**Aquind Interconnector application for a Development Consent Order
for the 'Aquind Interconnector' between Great Britain and France
(PINS reference: EN020022)**

**WRITTEN SUBMISSIONS IN RELATION TO ISSUE SPECIFIC
HEARING 1 INTO THE DRAFT DEVELOPMENT CONSENT ORDER**

Submitted in relation to Deadline 5 of the Examination Timetable

TITLE: Application document reference  
2.6 Converter Station and Telecommunications Buildings Parameter Plans  
Option B(ii)  
Sheet 3 of 3

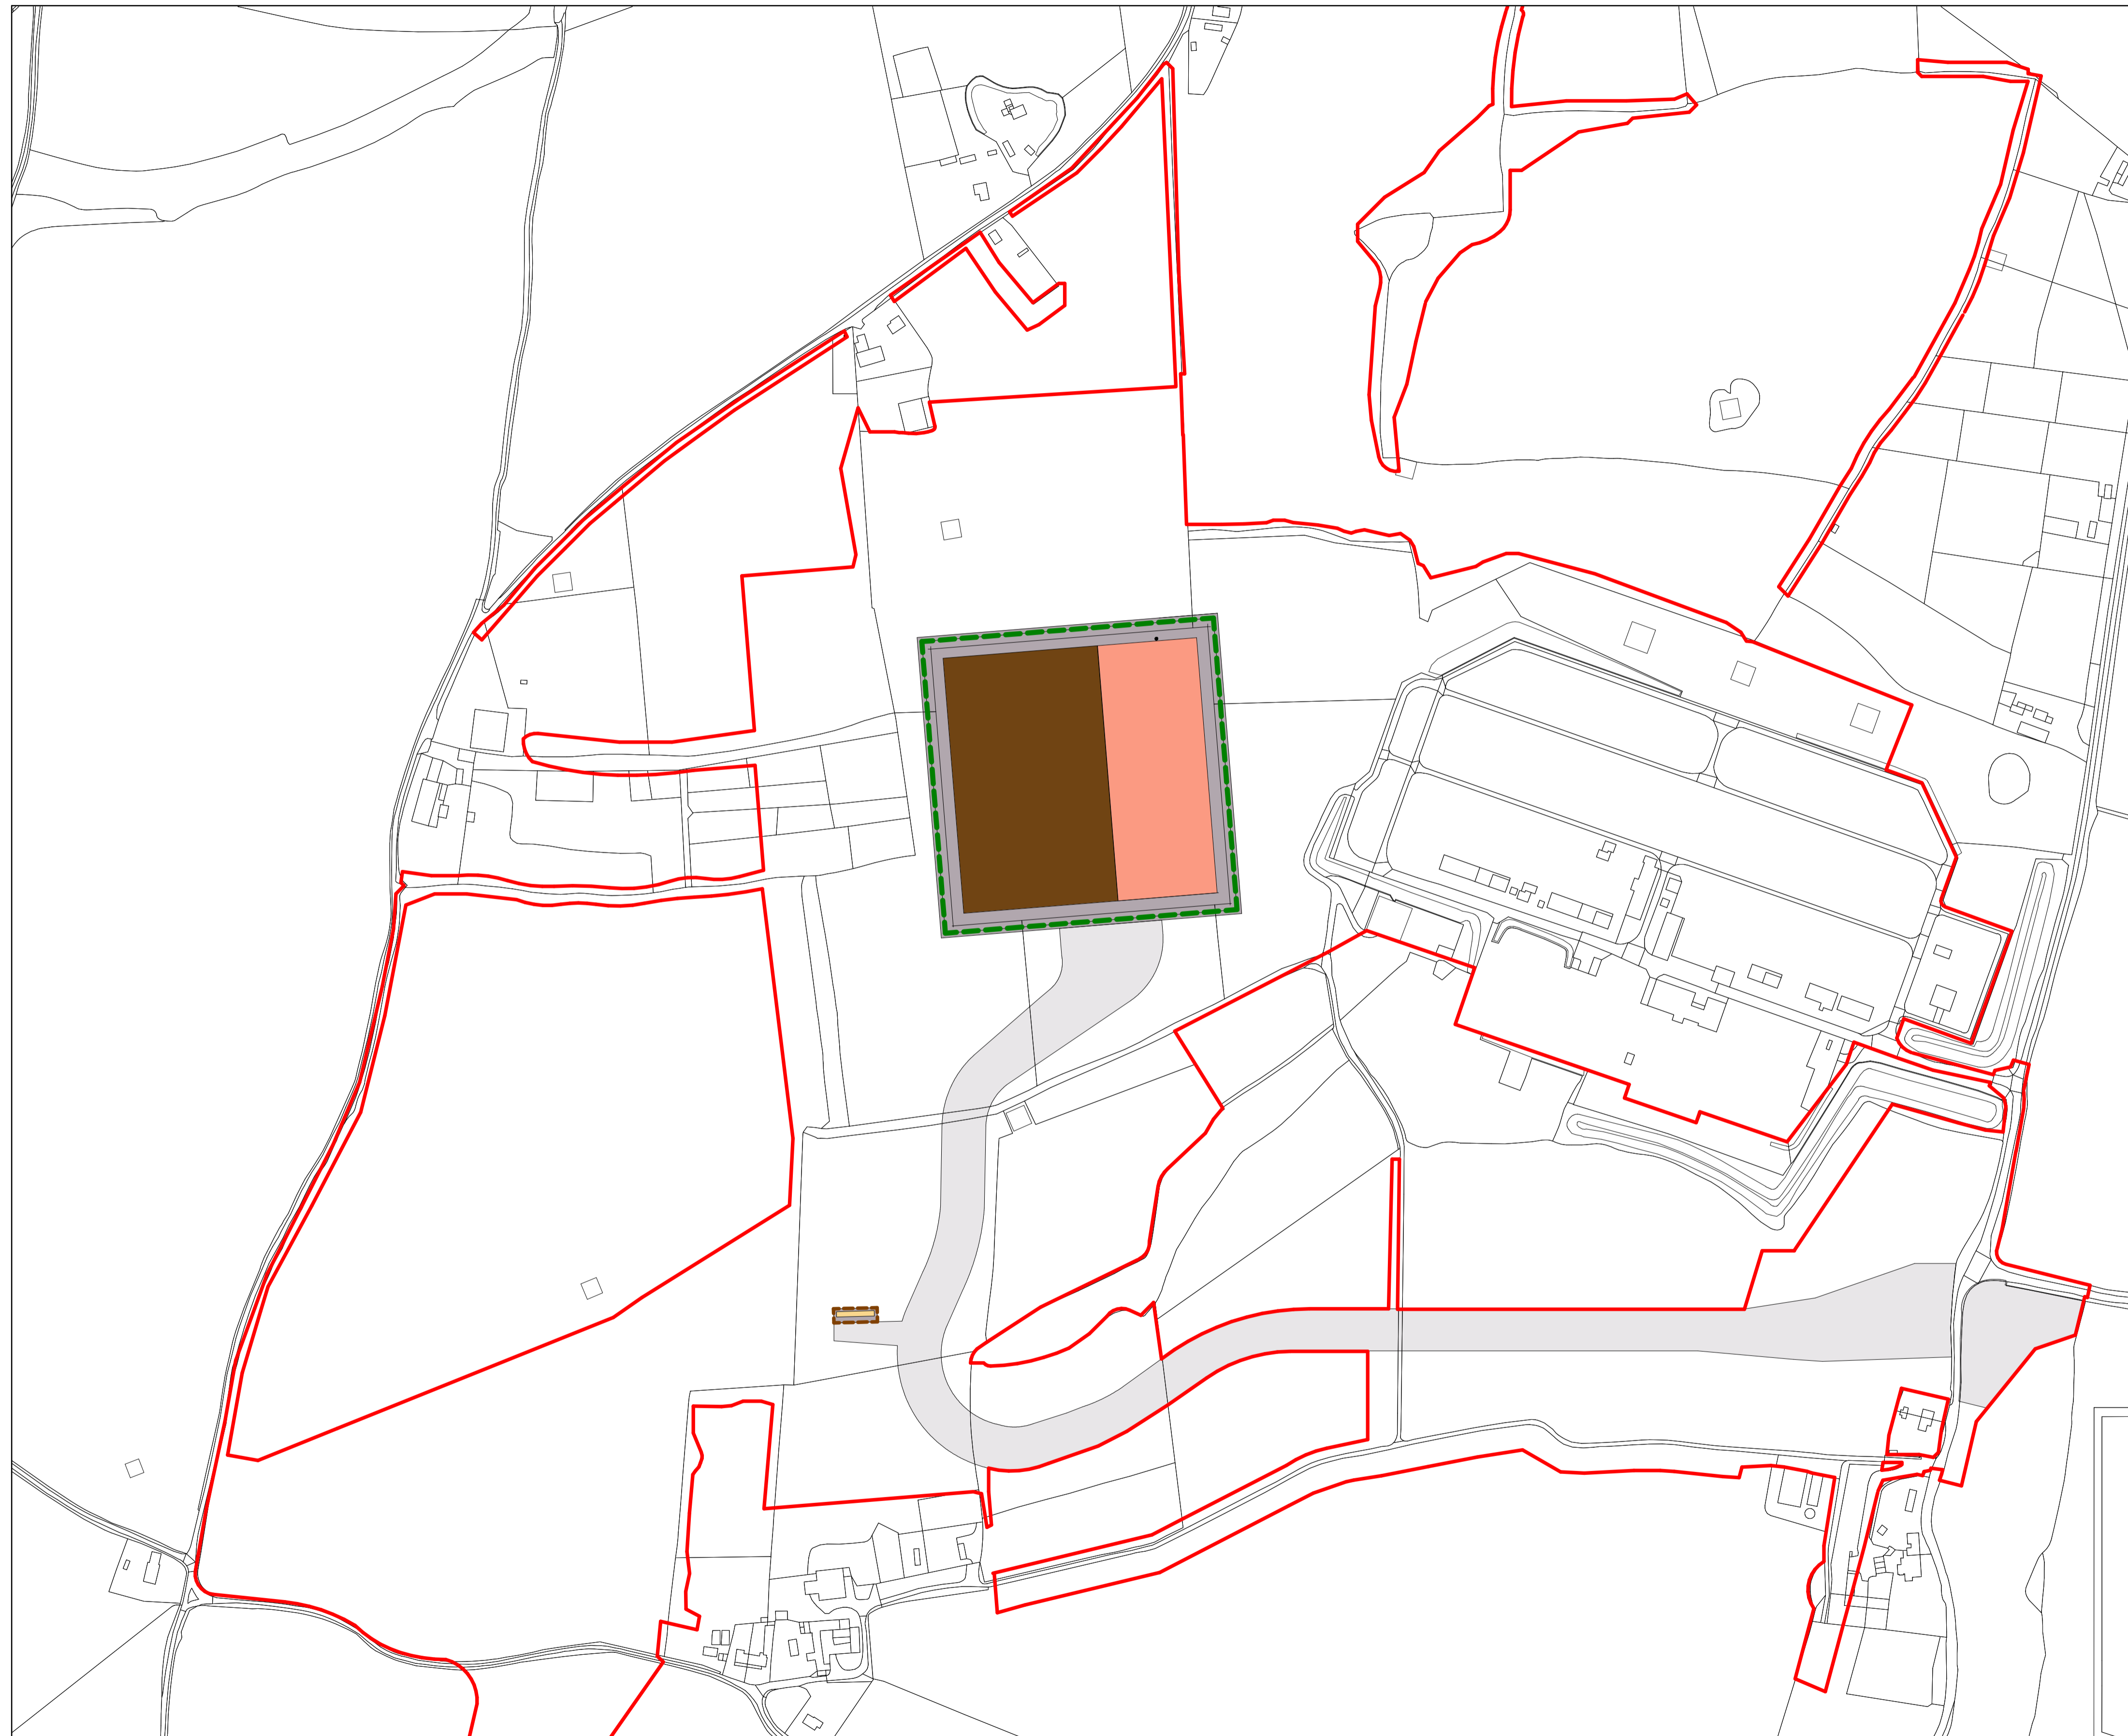
Provision in of Draft DCO (version as submitted by the Applicant at Deadline 3)	Required Amendment	Justification for Required Amendment					
			<p>that commercial purpose and so are not otherwise required.</p> <p>Please see the following documents for a fuller account of our position in relation to this:</p> <p>See column 4 of paragraphs 8 and 10 of Schedule 1 of document reference REP4-047; column 3 of paragraphs 2 and 7 of Schedule 2 of document reference REP4-047; and Schedule 4 of document reference REP4-047 Representations for Deadline 4 by Mr. Geoffrey Carpenter and Mr. Peter Carpenter (Registration Identification Number: 20025030).</p>					
28	<p>Schedule 7 Parameter Plans</p> <p>Drawing Number EN020022-2.6-PARA-Sheet3</p>	<p>DELETE the words "and Telecommunications Buildings" from the Column headed <i>Drawing Title</i>:</p> <table border="1" data-bbox="640 1267 1417 1378"> <tr> <td data-bbox="640 1267 831 1378"><i>EN020022-2.6-</i></td> <td data-bbox="831 1267 893 1378"><i>02</i></td> <td data-bbox="893 1267 1218 1378"><i>Converter Station and Telecommunications</i></td> <td data-bbox="1218 1267 1352 1378"><i>1:1,250</i></td> <td data-bbox="1352 1267 1417 1378"><i>A1</i></td> </tr> </table>	<i>EN020022-2.6-</i>	<i>02</i>	<i>Converter Station and Telecommunications</i>	<i>1:1,250</i>	<i>A1</i>	<p>The inclusion of fibre optic telecommunication cables for commercial purposes does not satisfy the relevant legal tests for being "Associated Development". The Telecommunications Buildings are exclusively required in relation to</p>
<i>EN020022-2.6-</i>	<i>02</i>	<i>Converter Station and Telecommunications</i>	<i>1:1,250</i>	<i>A1</i>

Provision in of Draft DCO (version as submitted by the Applicant at Deadline 3)	Required Amendment				Justification for Required Amendment
		<i>PARA-Sheet3</i>		<i>Buildings Parameter Plans Option B(ii) - Sheet 3 of 3</i>		<p>that commercial purpose and so are not otherwise required.</p> <p>Please see the following documents for a fuller account of our position in relation to this:</p> <p>See column 4 of paragraphs 8 and 10 of Schedule 1 of document reference REP4-047; column 3 of paragraphs 2 and 7 of Schedule 2 of document reference REP4-047; and Schedule 4 of document reference REP4-047 Representations for Deadline 4 by Mr. Geoffrey Carpenter and Mr. Peter Carpenter (Registration Identification Number: 20025030).</p>
29	<p>Schedule 7 Parameter Plans</p> <p>Drawing Number EN020022-2.6-PARA-Sheet3</p>	AMEND Drawing Number EN020022-2.6-PARA-Sheet3 to remove the Telecommunications Buildings from it				<p>The inclusion of fibre optic telecommunication cables for commercial purposes cannot and does not satisfy the relevant legal tests for being "Associated Development". The Telecommunications Buildings are exclusively required in relation to that commercial purpose and so are not otherwise required.</p>
